**North Carolina Department of Health and Human Services**  
**Division of Public Health**

August 3, 2020

RE: Tropical Smoothie Cafe  
1546 NC Hwy 24/87  
Cameron, NC 28326

This letter acknowledges review of the plan for the above remodel of the referenced establishment. The original plan dated 03/05/2020 and specifications are approved with the following comments:

A4.0

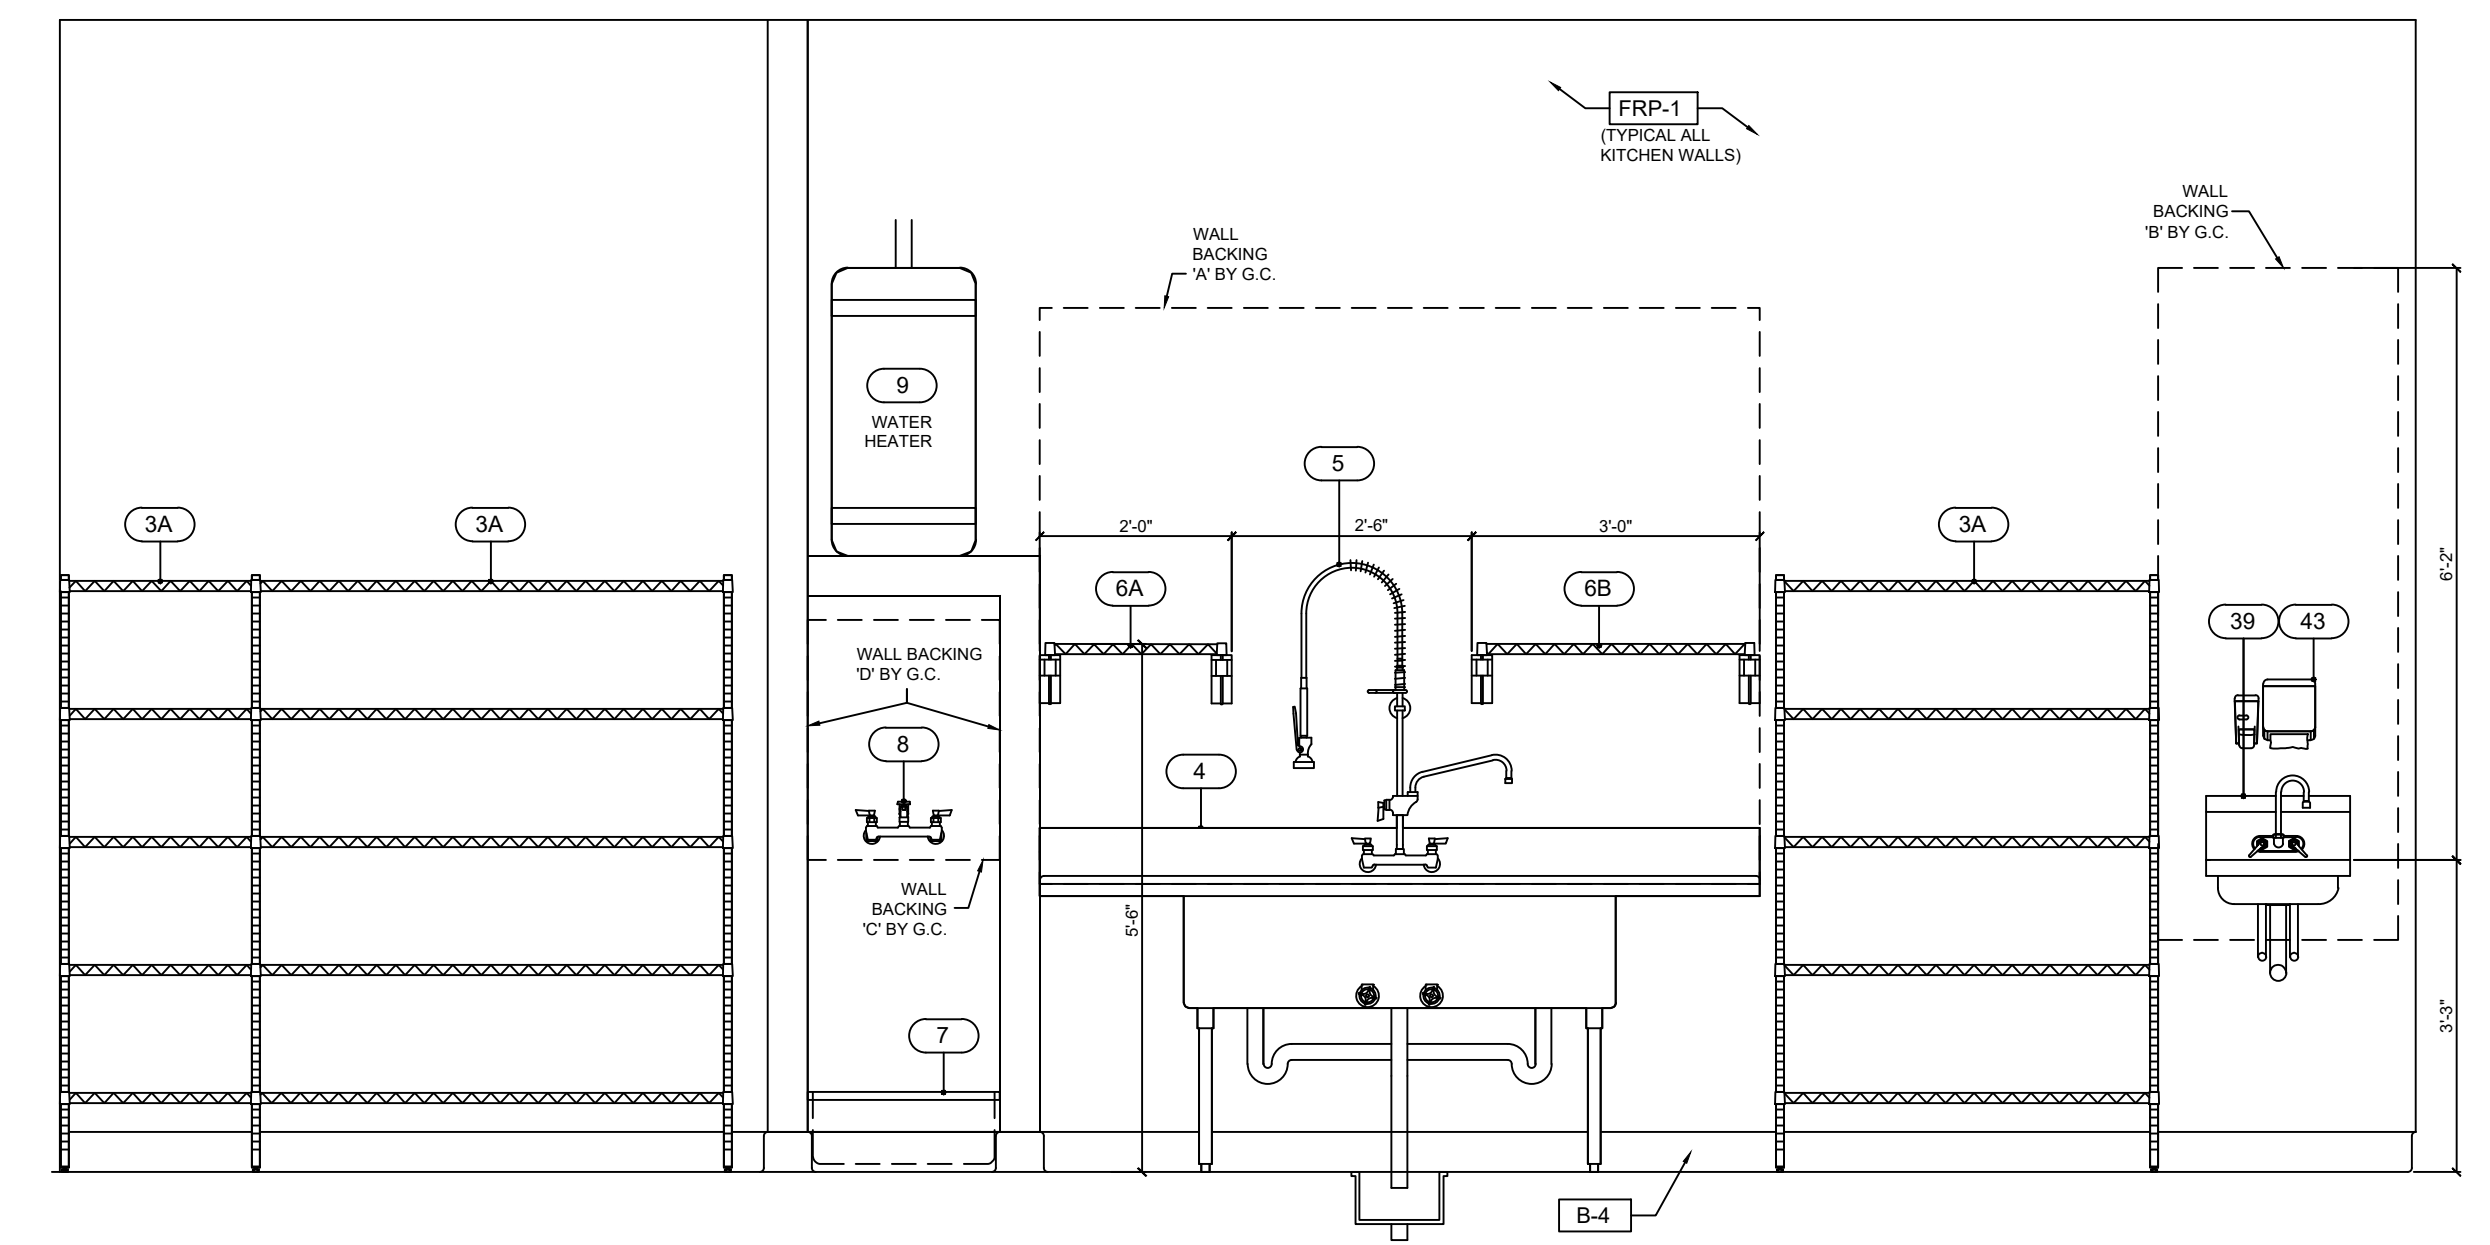
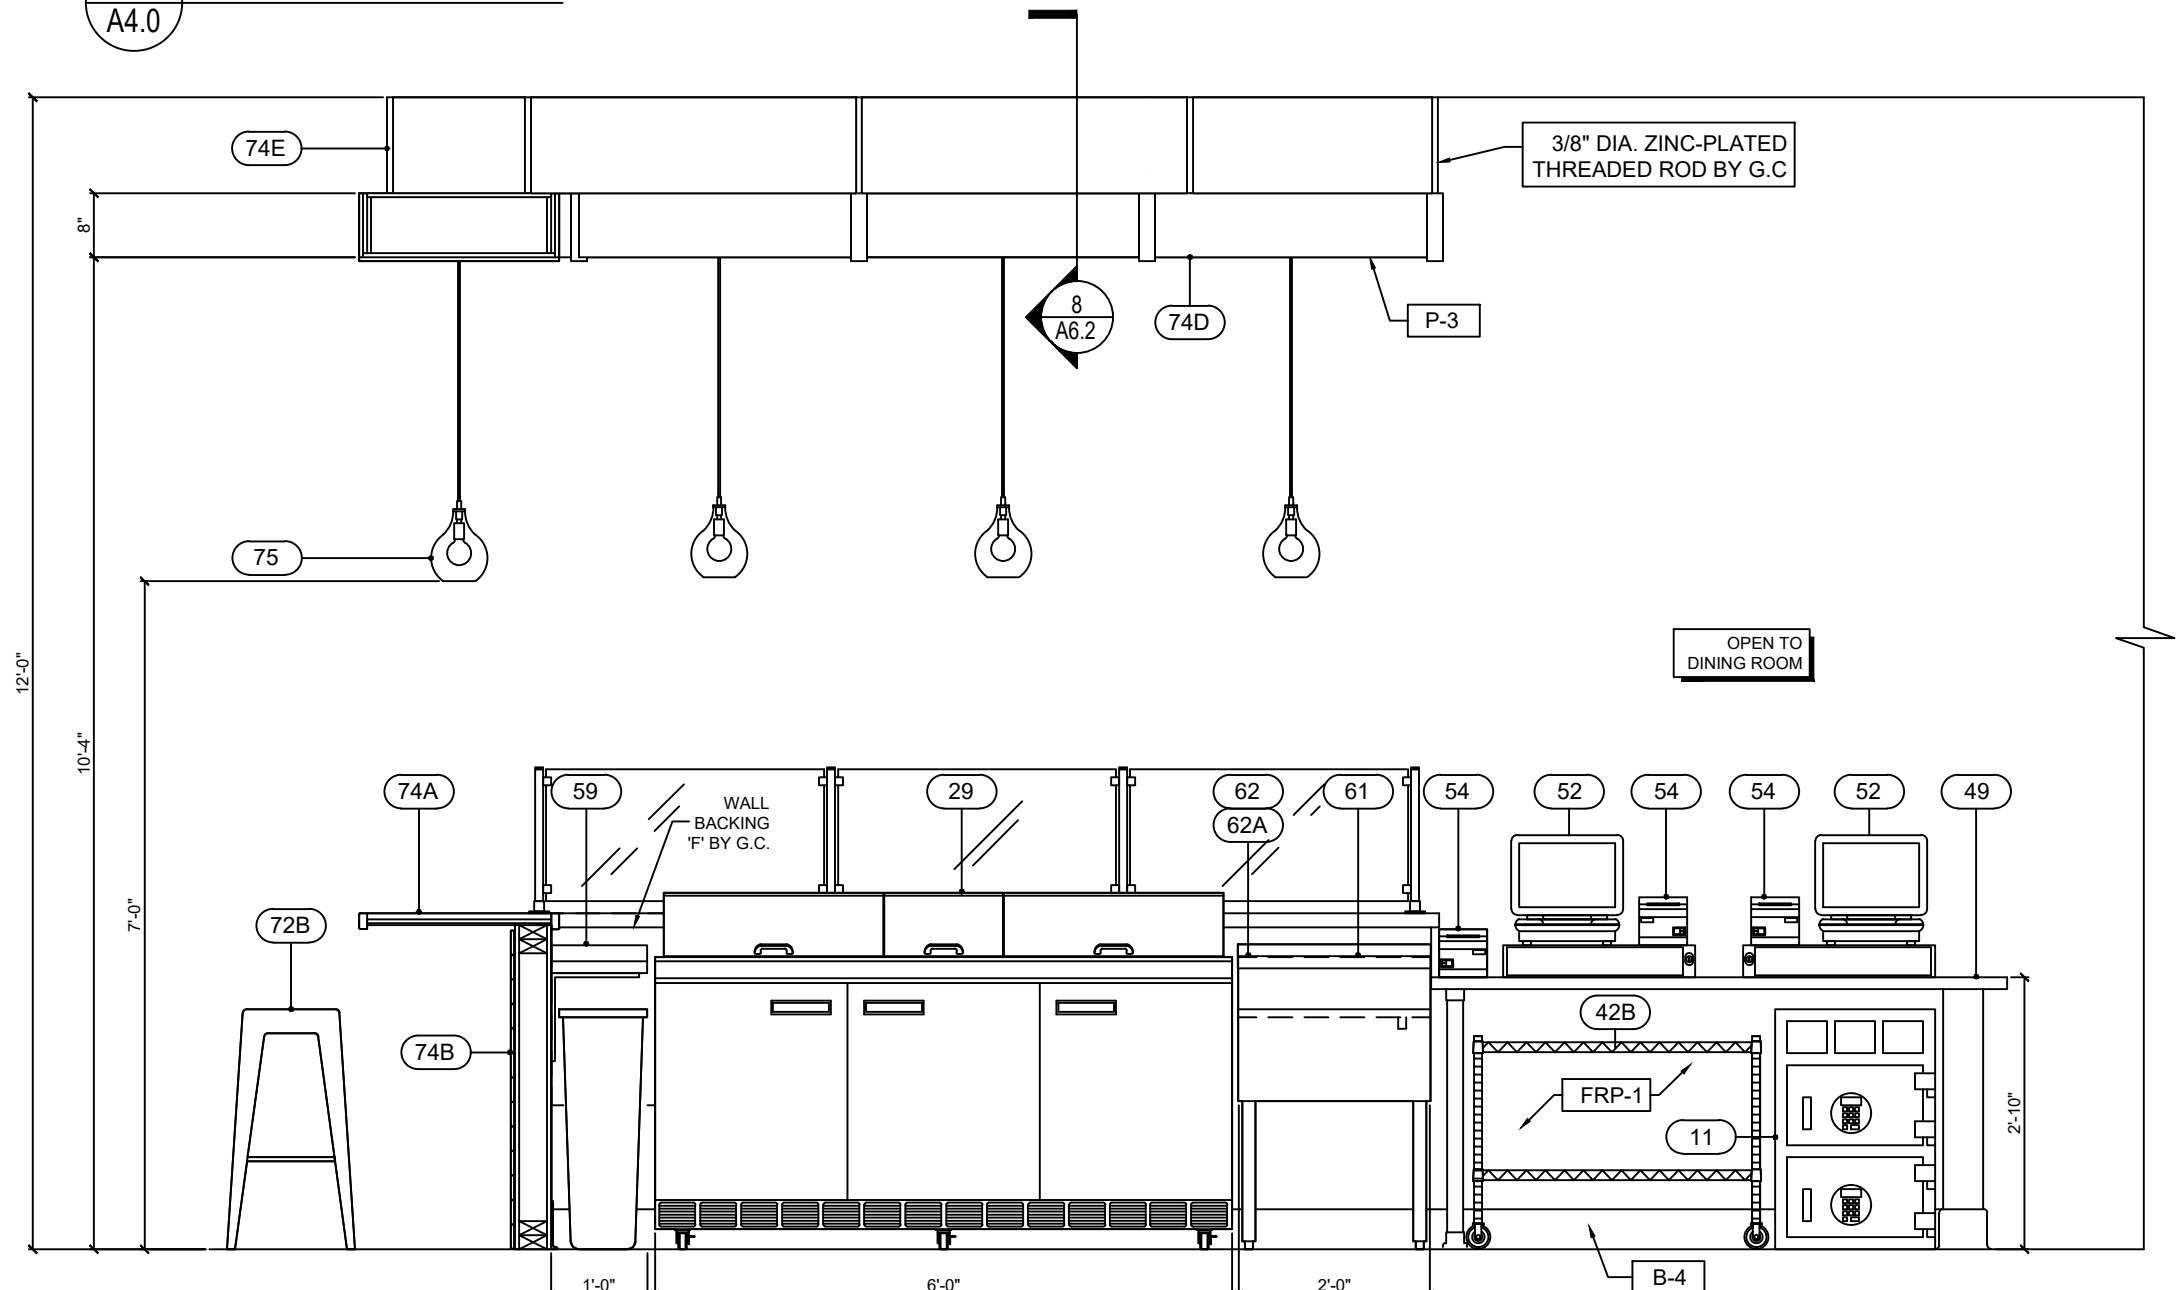
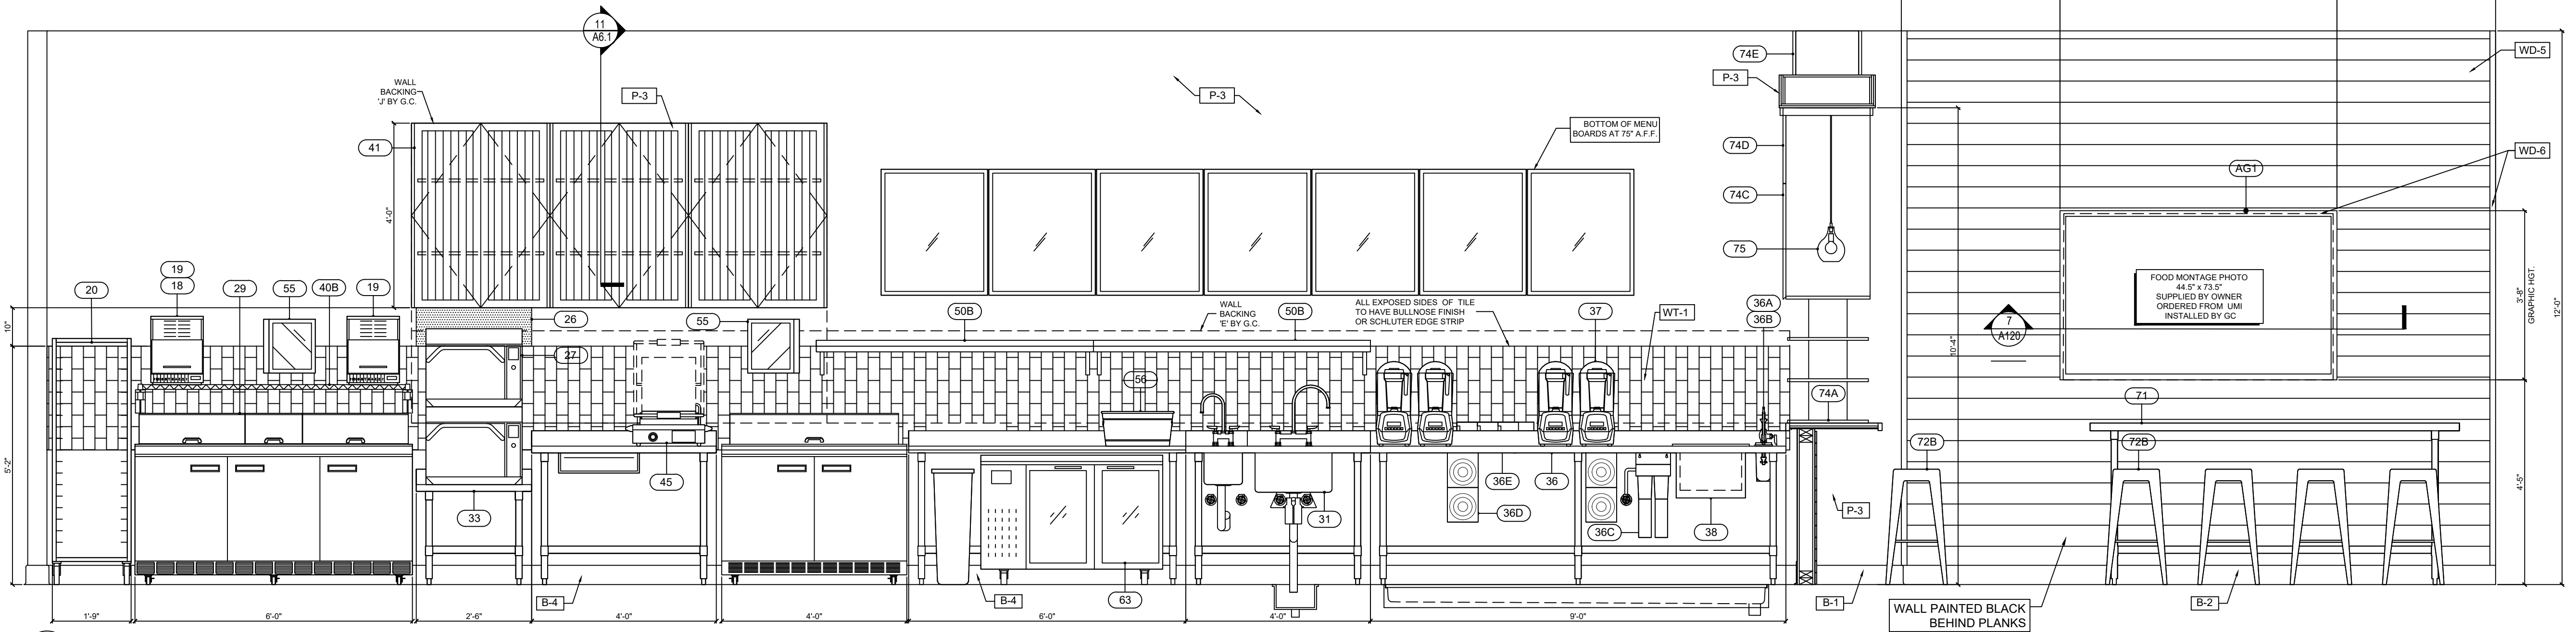
2. Splash guards will need to be installed where there is a concern for sink splash to prevent potential contamination.  
Sneeze guards will be installed as shown on elevation plan sheets 4.0 and 4.1, and on the Equipment Plan sheet A5.0.  
A covered waste receptacle will need to be provided for the disposal of sanitary napkins to meet NC Food Code requirements.
